**Addendum No. 1**

RE: Contract ID: C201324  
WBS# 33240.3.1  
F. A. # BRZ-1214 (3)  
Stanly County (B-3700)  
Bridge over Long Creek  
And Approaches on SR-1214.

**May 17, 2005 Letting**

SUPERSTRUCTURE  
 TYPICAL SECTION  
 AND DETAILS

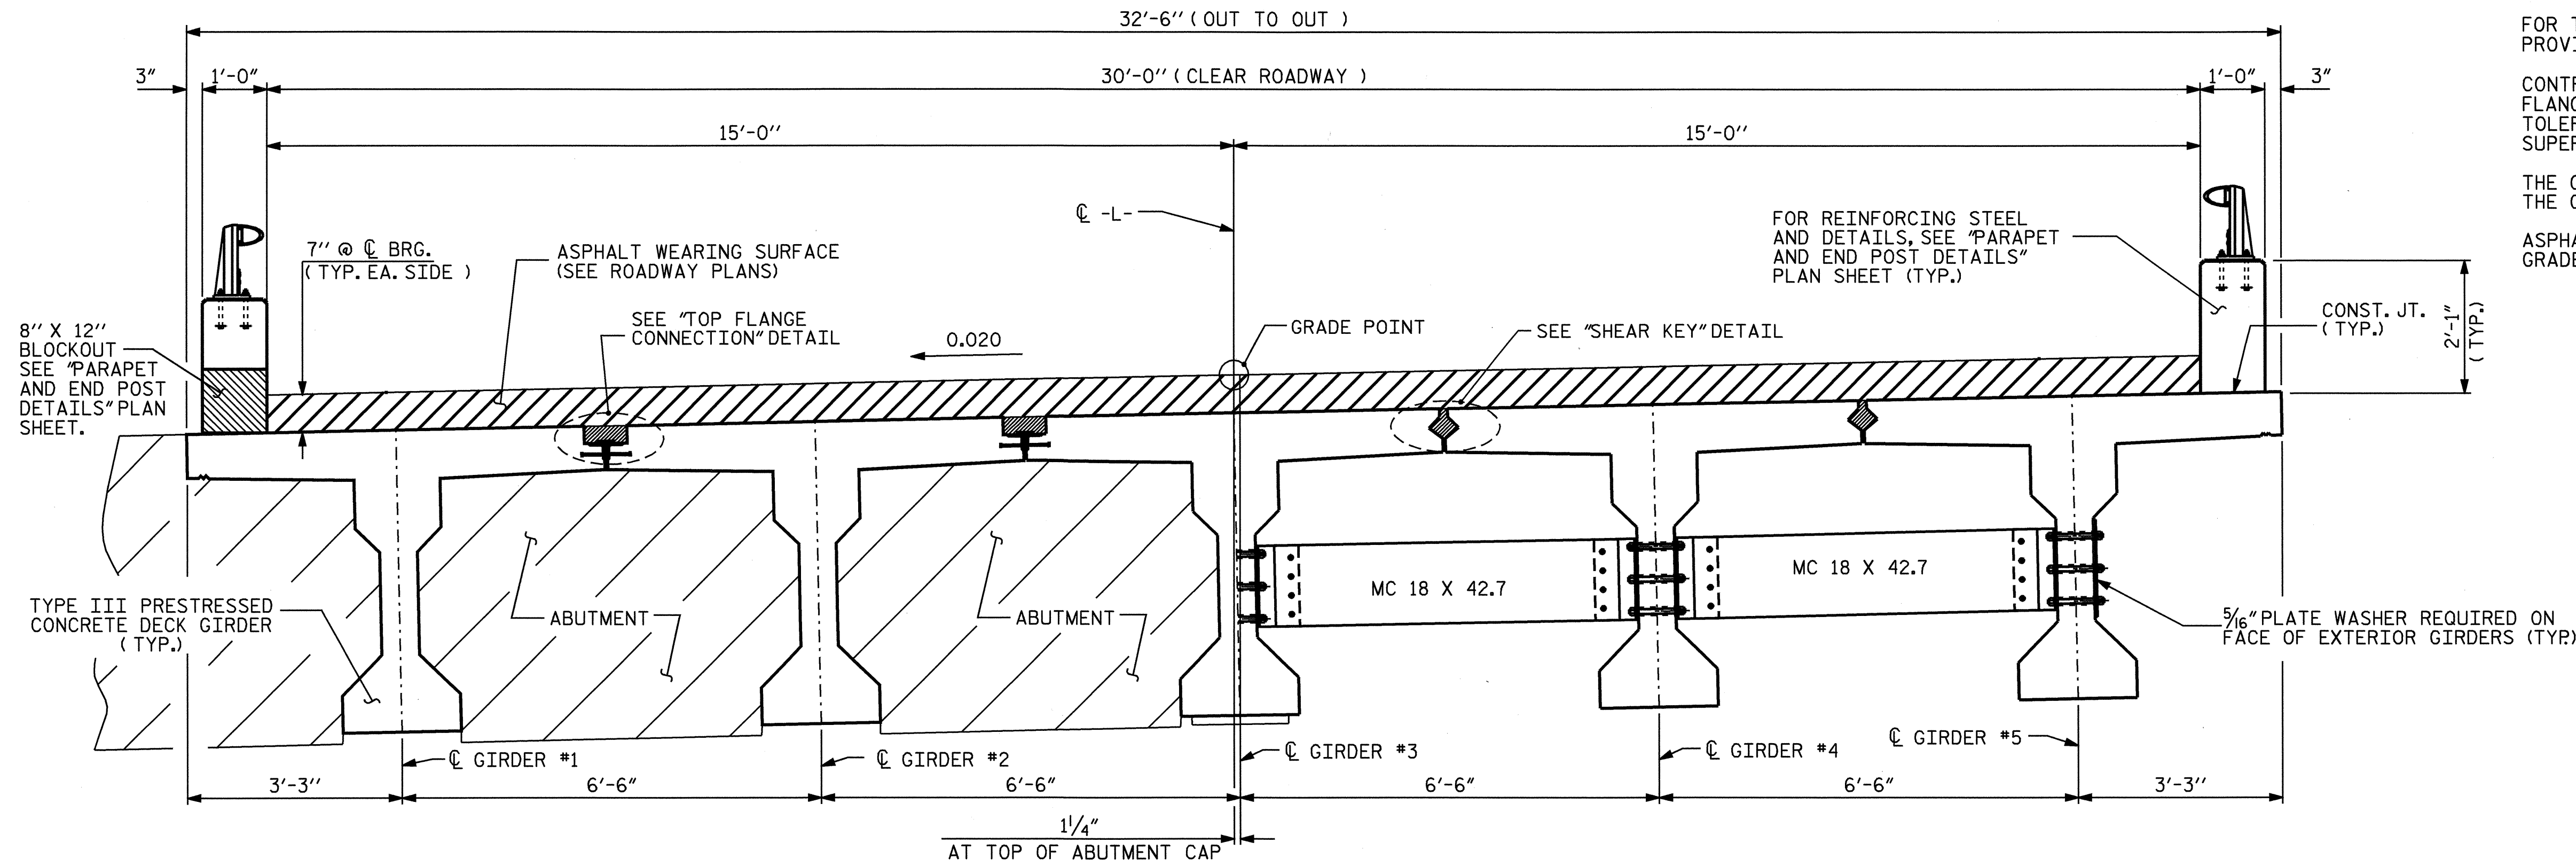
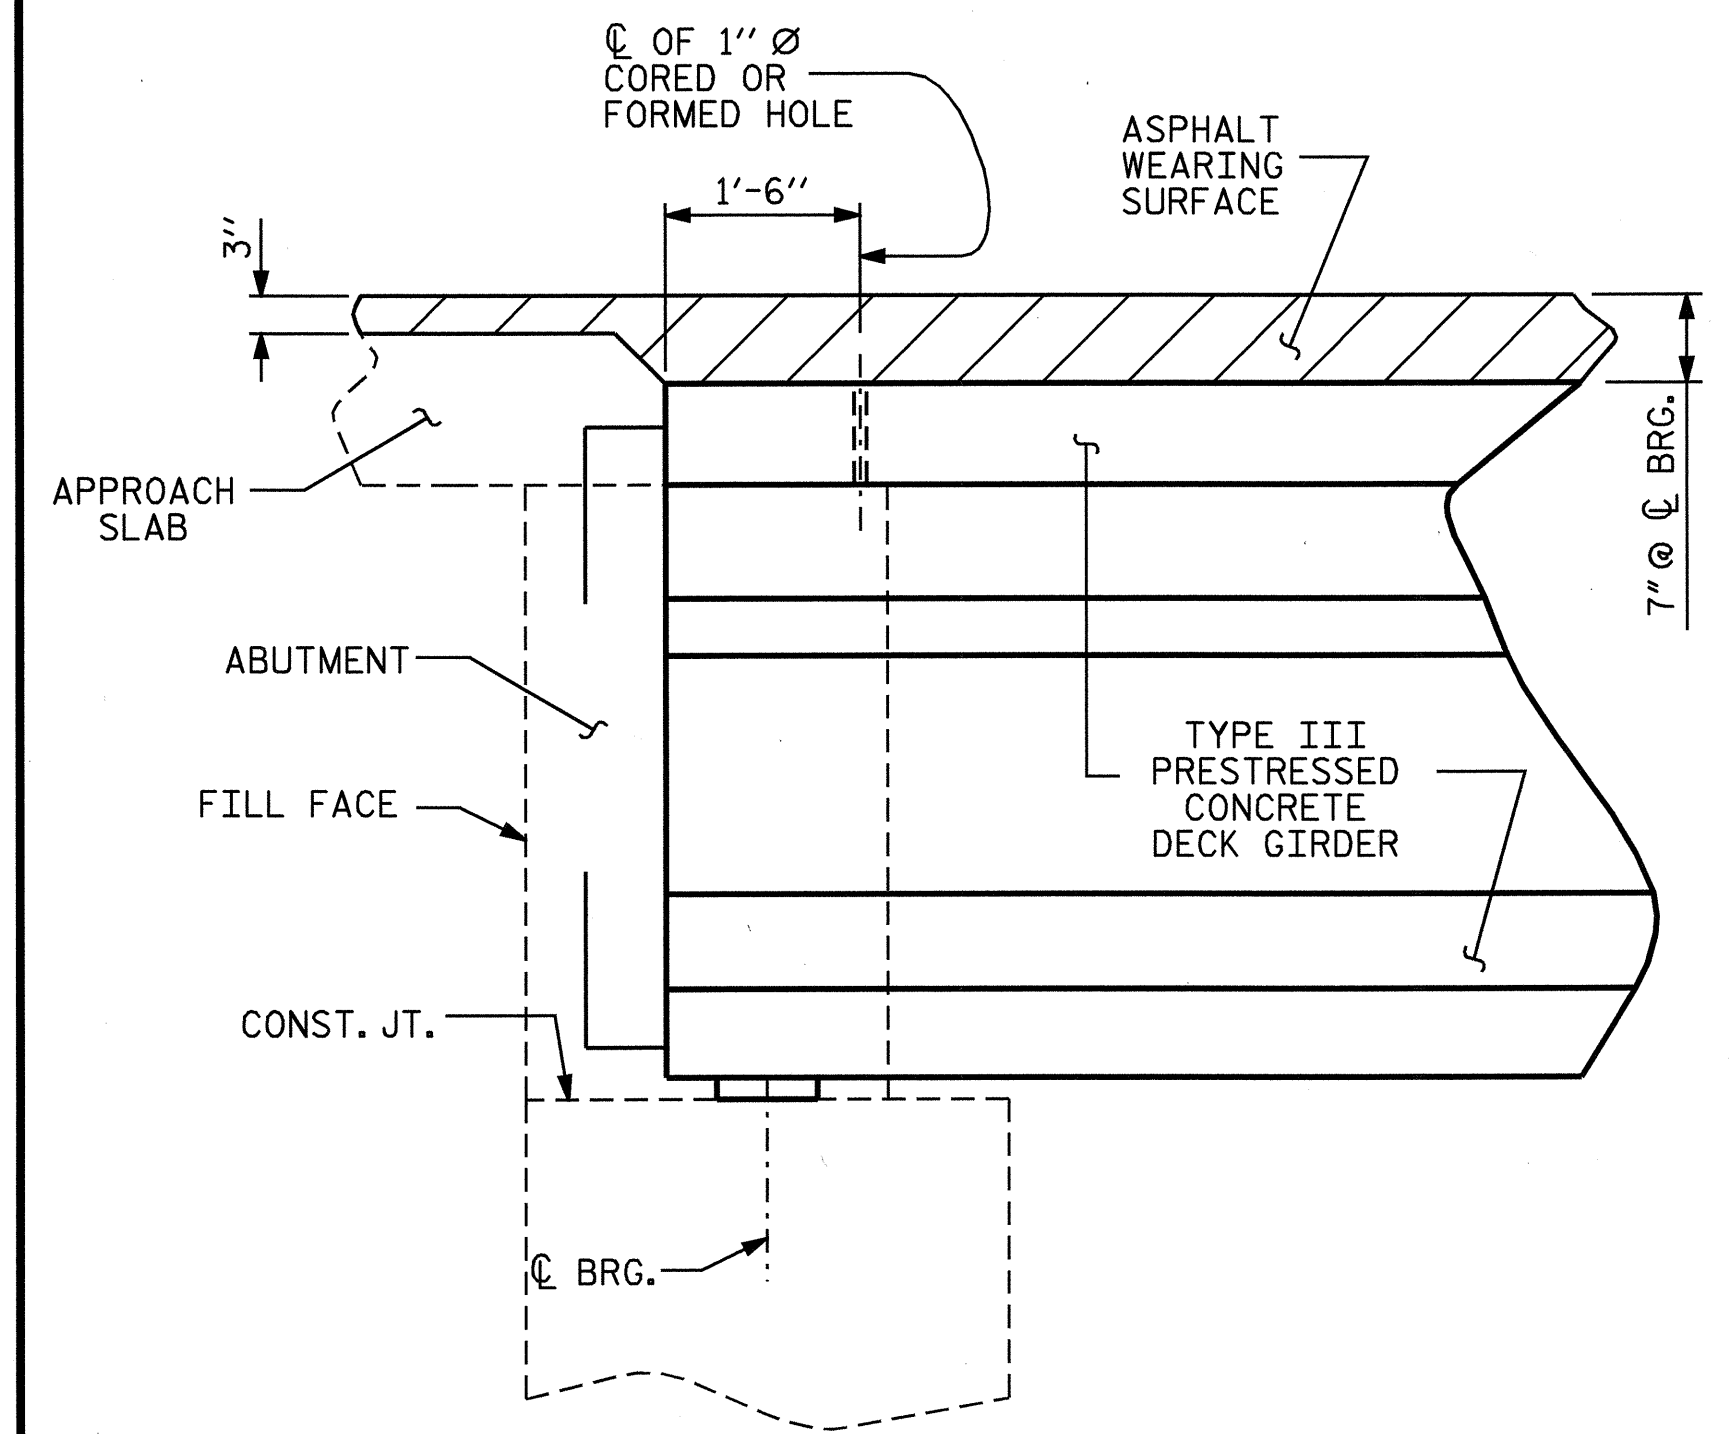
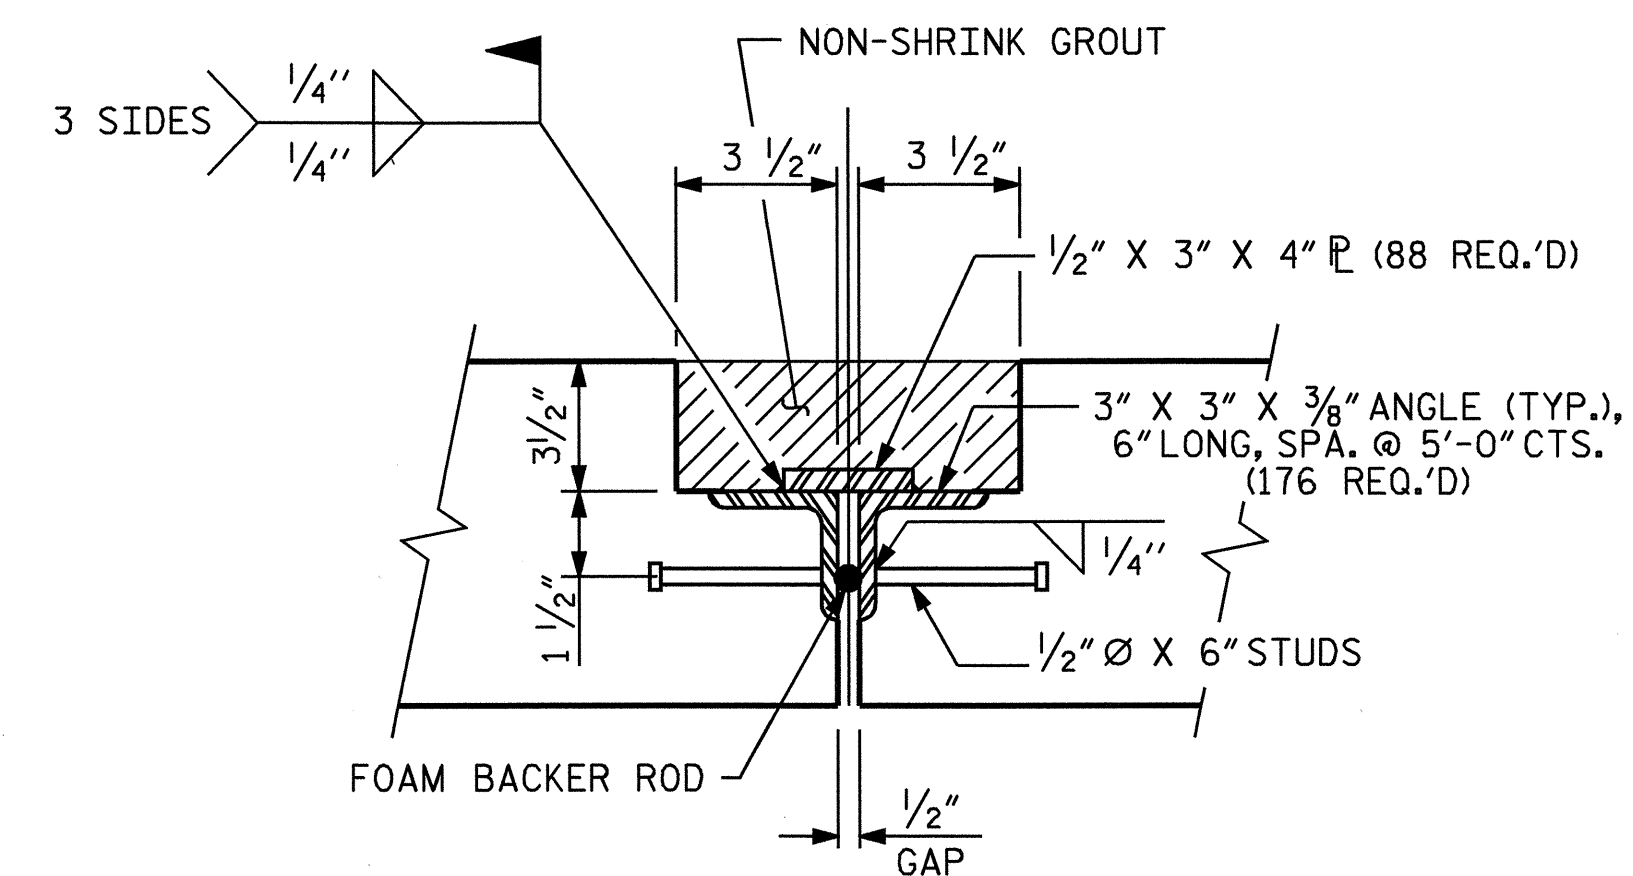
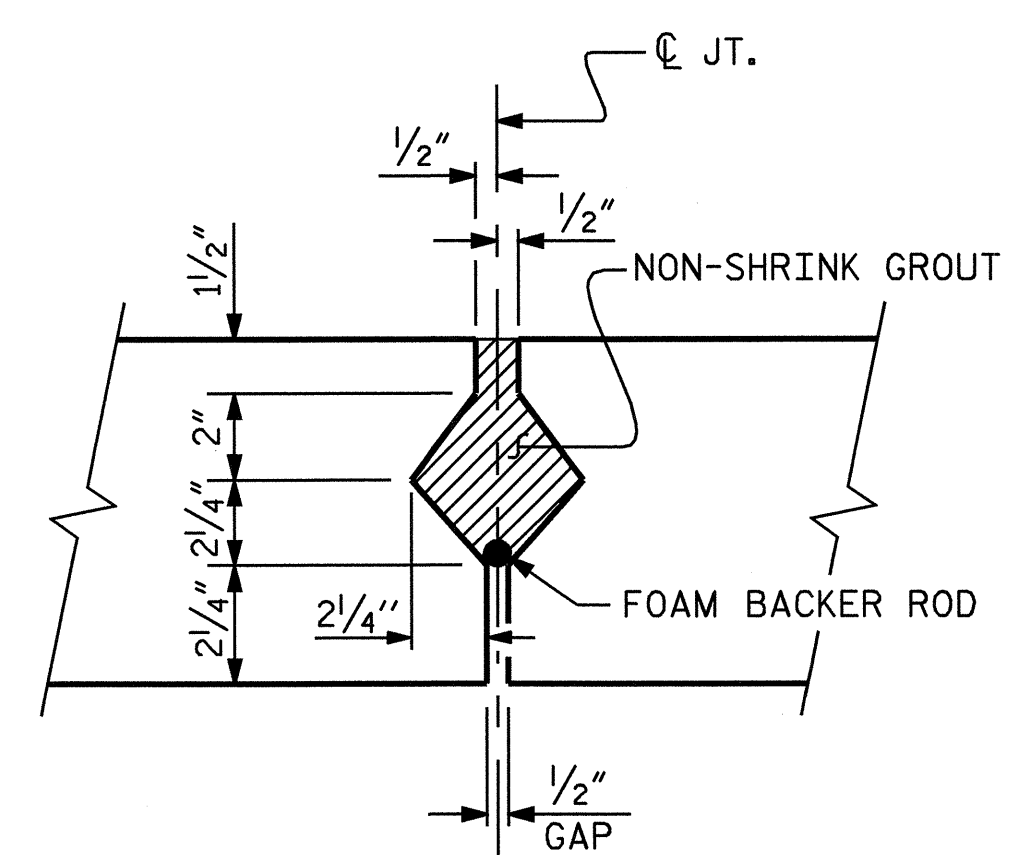
On Sheet No. S-4 a note was added concerning the plate washer required on the exterior girder. Please void Sheet No. S-4 in your plans and staple the revised Sheet No. S-4 thereto.
